**Shivesh Singh - RE: Proposed development, Scottish Hospital, 2 cooper Street, Paddington.**

Re; Scottish Hospital, 2 Cooper Street,, Paddington.

Application No. MP10\_0160

STEPHEN STREET ELEVATION

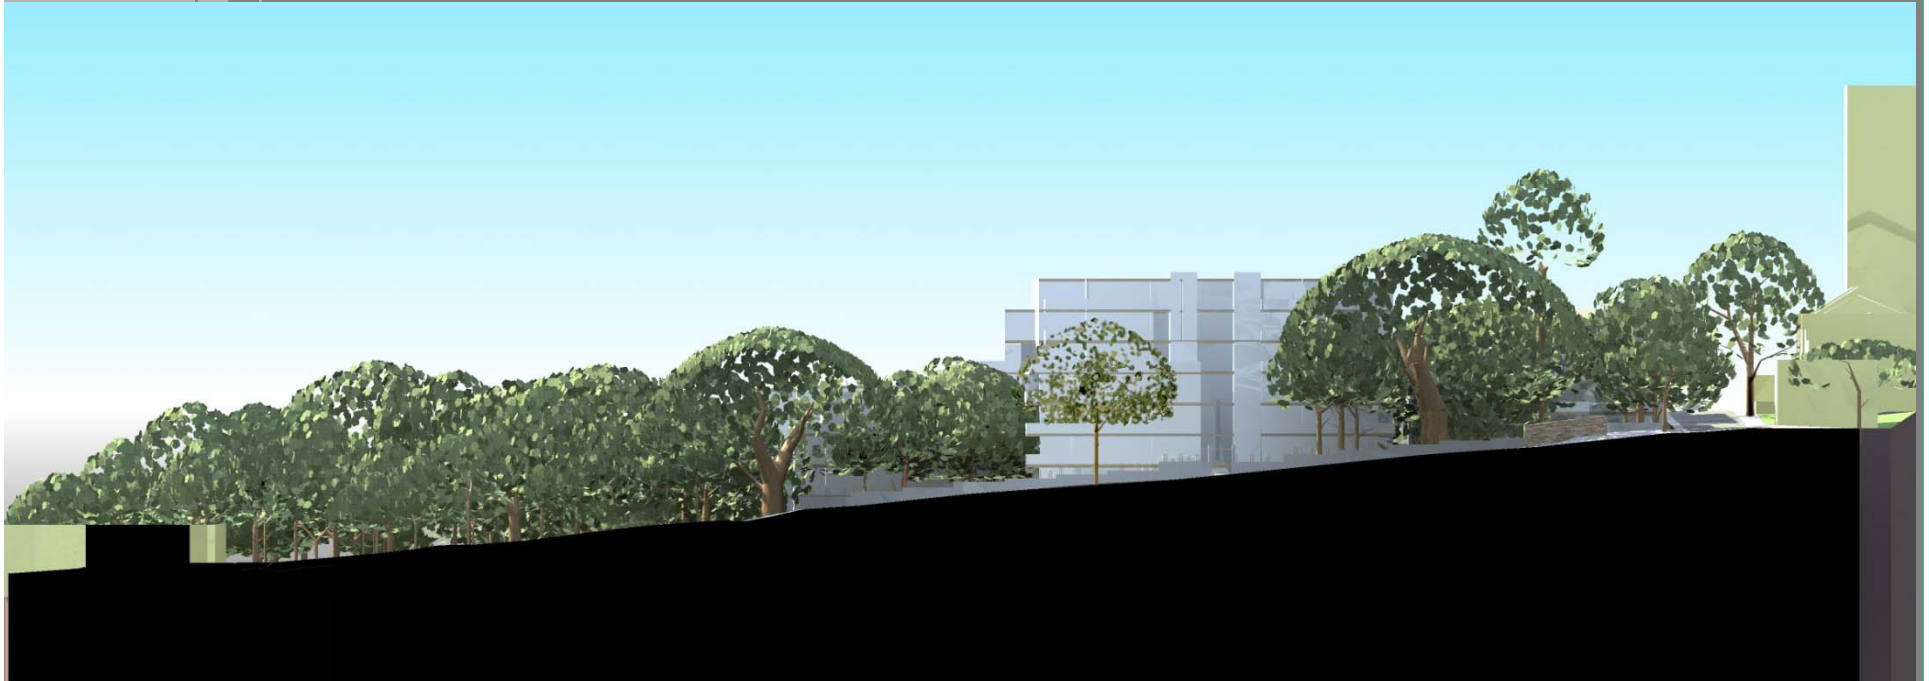
It requires all the big, mature trees to be removed in Stephen Street, to accommodate the building, replacing them with much smaller, decorative trees which won't give screening or privacy.

The scale of the proposed building will 'wall - in' the narrow street & will substantially reduce light, particularly afternoon light, by casting a large shadow, extending across our building & grounds. The view from my living area at present is of beautiful mature trees, giving changing patterns of light & shade throughout the day & absolute privacy, which is also a major concern with five floors directly facing.

The huge footprint of the proposed development, in height & length, is too big for the location & will have a brutal impact on those in our building & locality. A more considered & sympathetic design could reflect Harry Seidler's idea of a taller building with a smaller footprint, & a smaller building alongside, allowing a corridor, for through views, for those living opposite & retaining some mature trees at our end of Stephen Street.
